From: Robert Findlay
Sent: 03 July 2008 14:15
To: Planning.Responses
Subject: FW: Planning Consultation on: BR/183/08/

APPLICATION NO: BR/183/08/

Registered: 24-JUN-08
Site Address: 1 Stanford Close Bognor Regis

Description of Works: Sub division of existing dwelling as two houses.

Title
Plans and Elevations
As Proposed

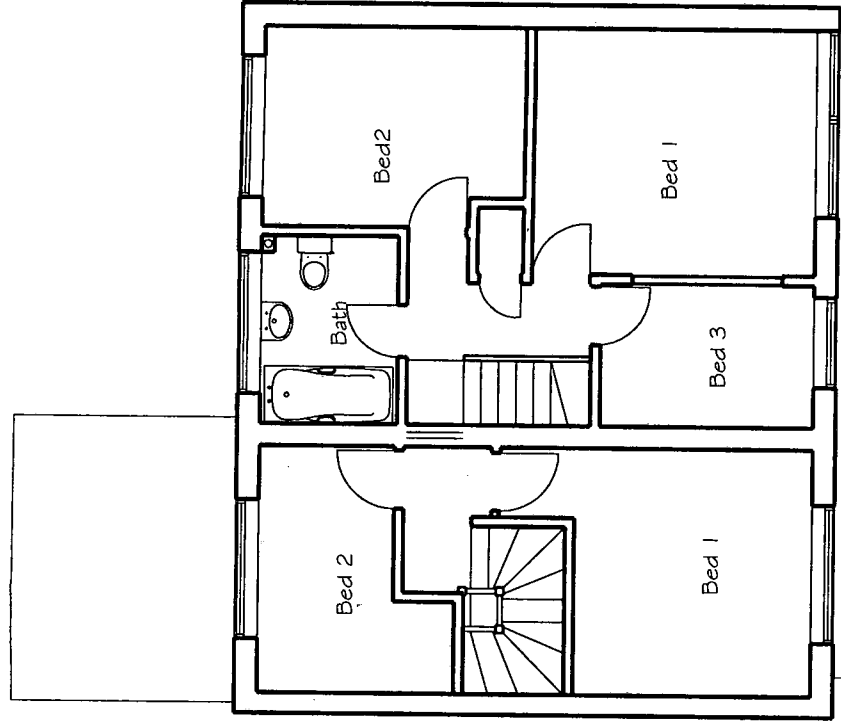
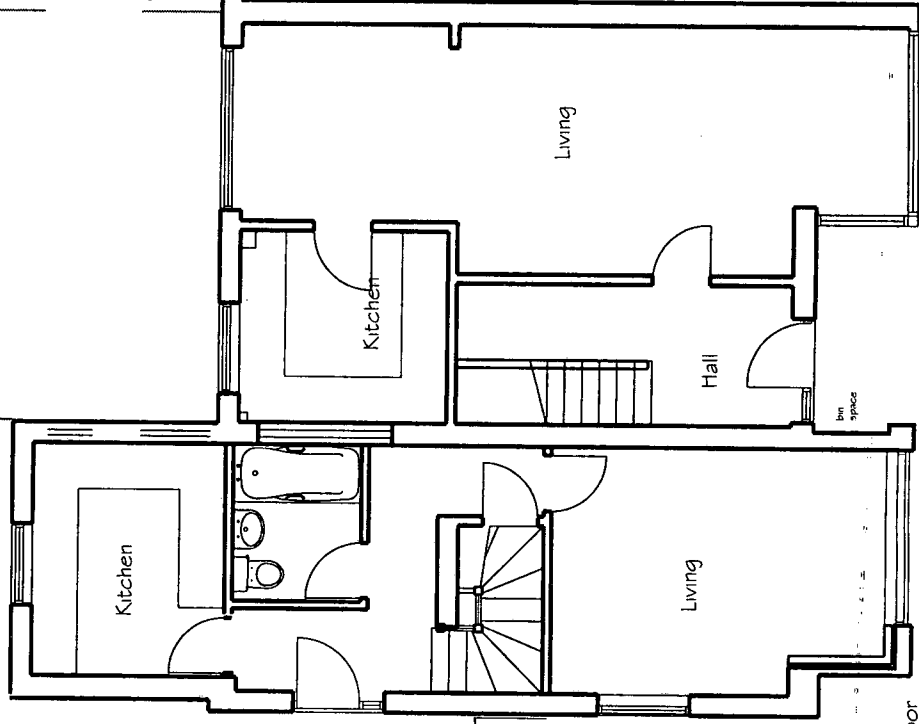
bedroom sizes should be as follows
Main bedrooms at least 10 sq m

additional bedrooms at least 7 sq m

with this in mind bedroom 2 of the 2 bed roomed unit and bedroom 3 of the 3 bed roomed unit are e too small, in addition bedroom 2 of the 2 bed roomed unit is of poor design.

Should a housing Health and Safety rating System inspection be undertaken and the properties are privately rented it is likely that formal notices may restrict the occupation of the dwellings, with regards overcrowding and space.
